CITY OF ALBUQUERQUE

**RE: Tuyet Son Buddhist Center
12125 Central Ave NE
Grading and Drainage Plan
Engineers Stamp Date 9/20/16 (L22D060)**

From: Rael, Rudy E.
Sent: Tuesday, September 20, 2016 2:34 PM
To: 'David Soule (david@riograndeengineering.com)'
Cc: Carrillo, Abiel X.
Subject: Tuyet Son Buddhist Center

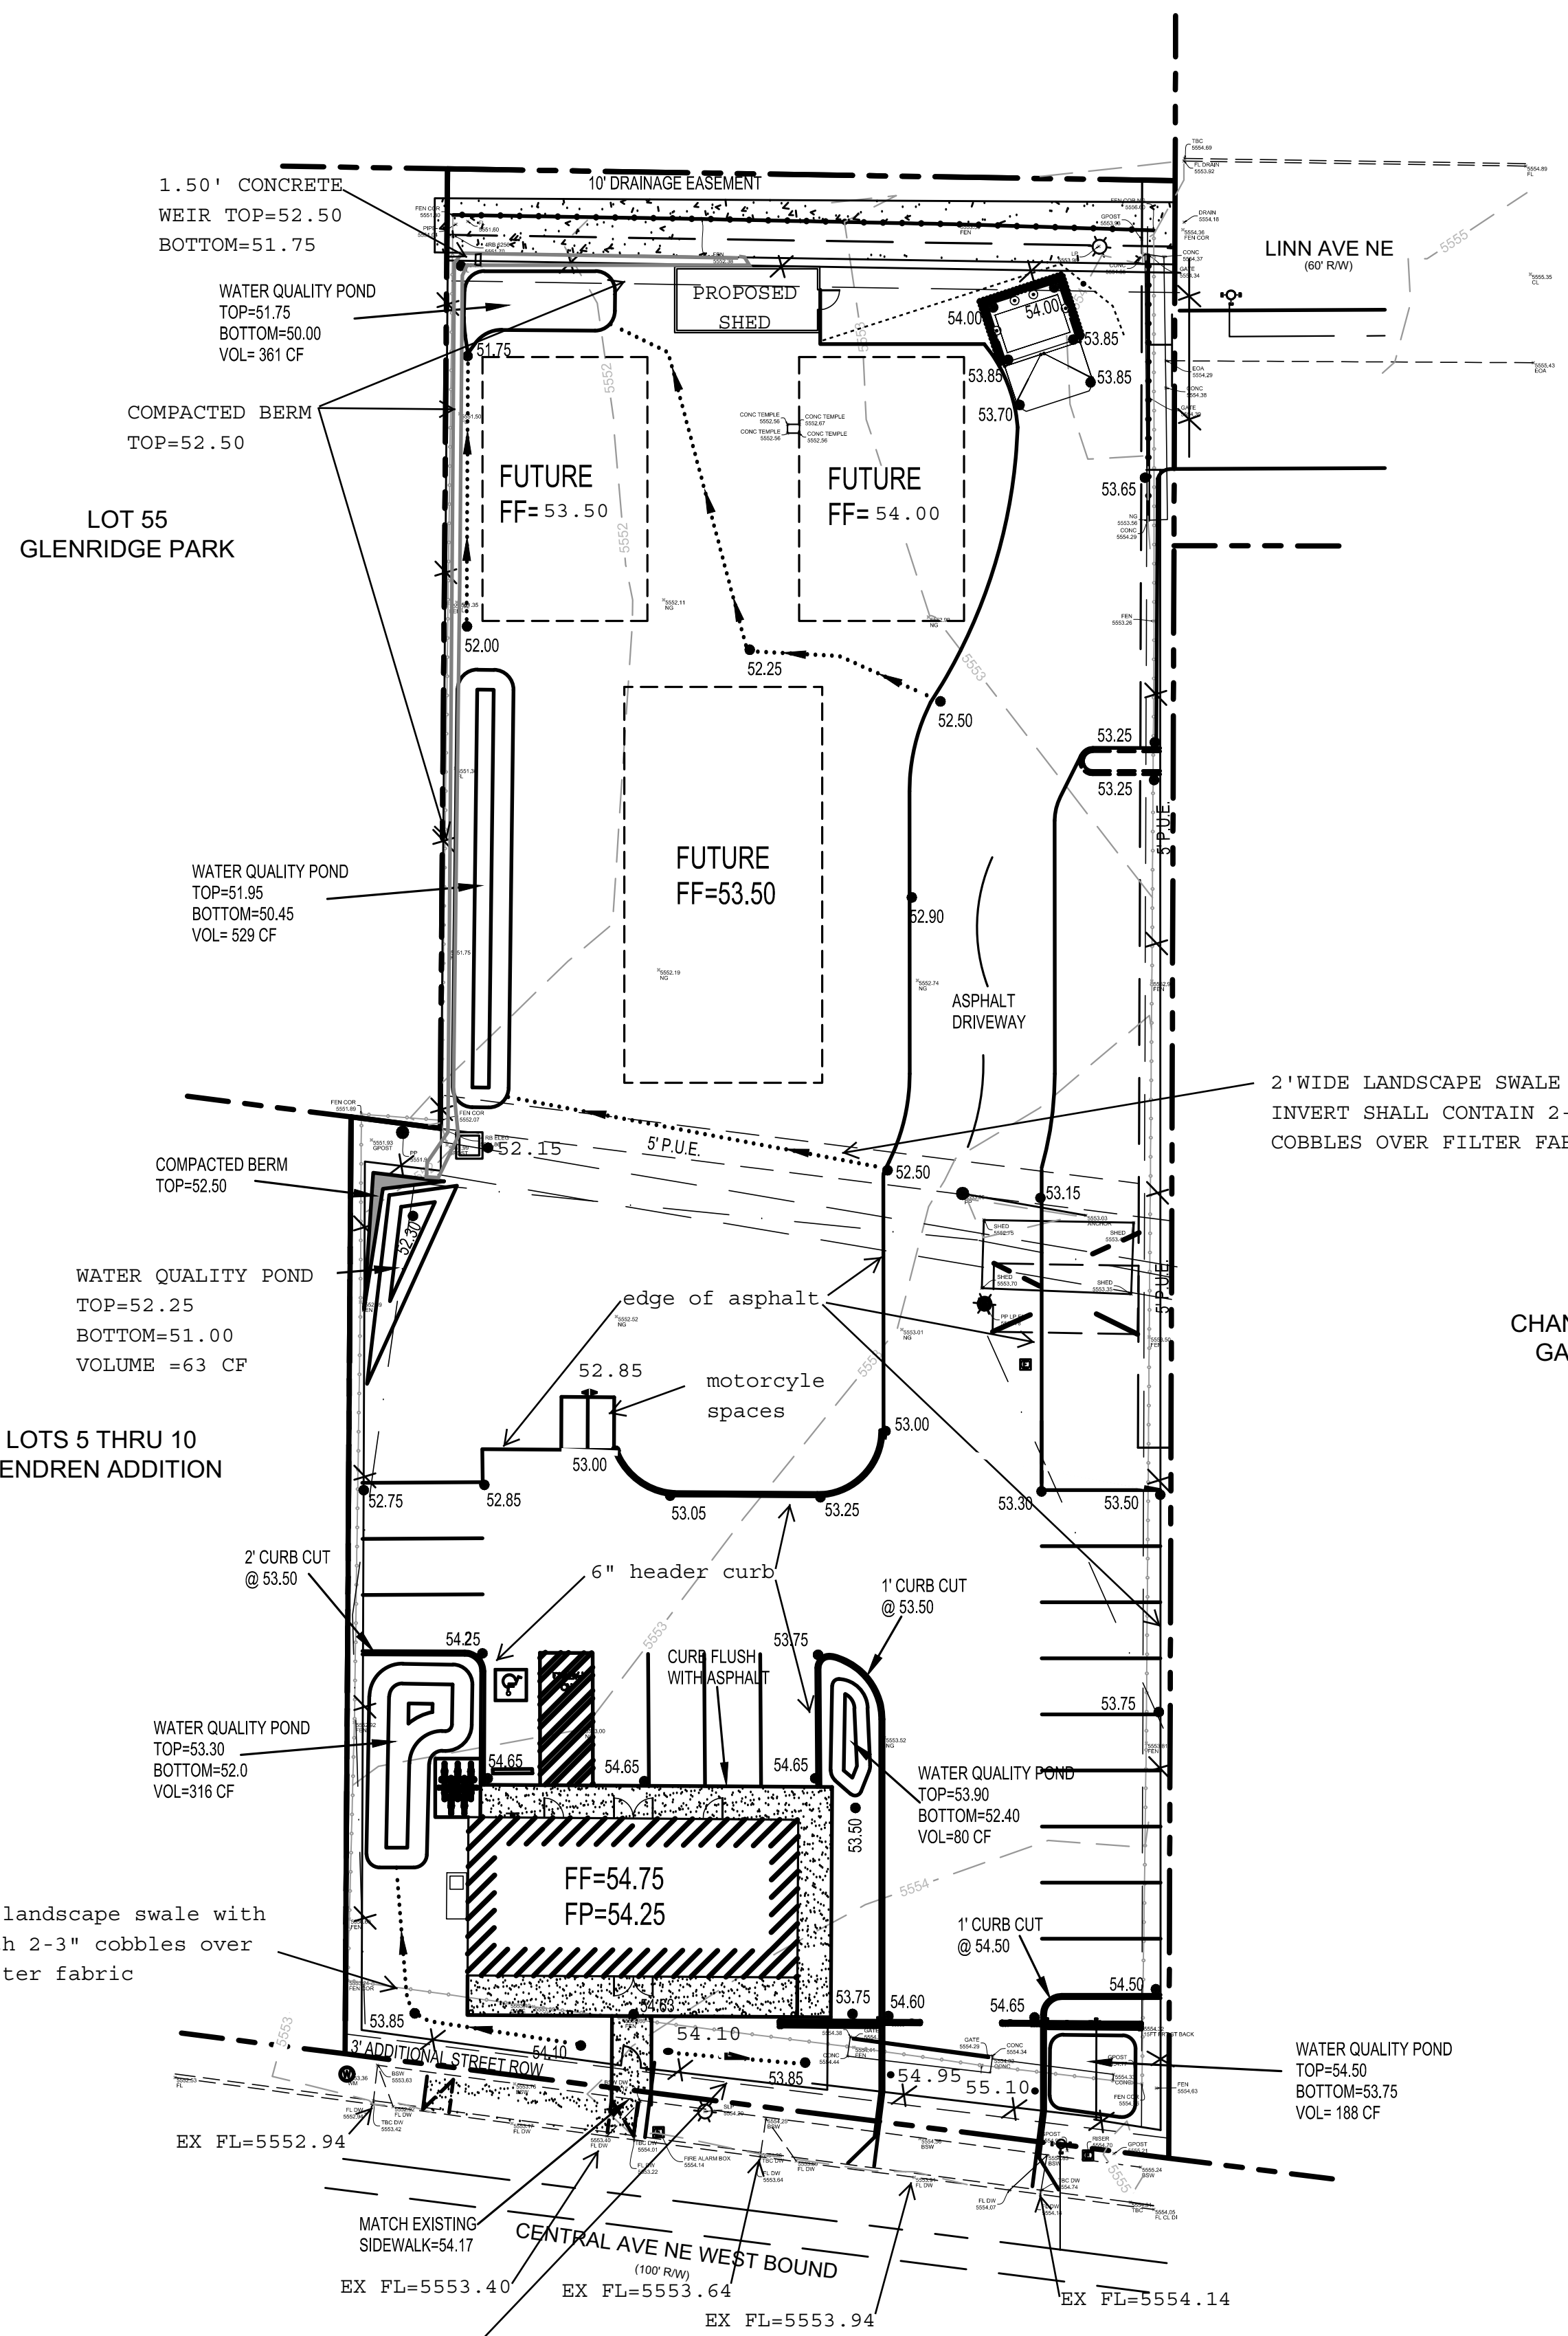
- Provide a detail for the compacted Berm. Will it be protected from erosion?
- At the northern end of the property there is a box with a door, is this a future building or a pond?
- Are the ponds sized for the future buildings?
- Are the dark lines between the existing pavement and new pavement curbing?
- What is the double box at elevation point 53.00?
- Provide a water block at the entrance of this site.
- Increase the font on the flow points in Central Ave.
- At the front of the new building, is the dotted line a swale as called out in the center of the property?
If so, how will flows pass the sidewalk from east to west. Provide a detail or a note.

- Provide a detail for the compacted Berm. Will it be protected from erosion? we have added a berm detail
- At the northern end of the property there is a box with a door, is this a future building or a pond? We have labeled as a shed

- Are the ponds sized for the future buildings? We have accounted for the future buildings, but the site improvements to the buildings are not known, so the plan will need to be updated once a site plan is fully developed for the future buildings

- Are the dark lines between the existing pavement and new pavement curbing? We have labeled the curbs and edges of asphalt
- What is the double box at elevation point 53.00? we have labeled the motorcycle spaces

- Provide a water block at the entrance of this site. we have added a one foot water block
- Increase the font on the flow points in Central Ave. we have increased call outs of the flowlines on Central.

- At the front of the new building, is the dotted line a swale as called out in the center of the property? we have added call out and corrected direction of flow
If so, how will flows pass the sidewalk from east to west. Provide a detail or a note.
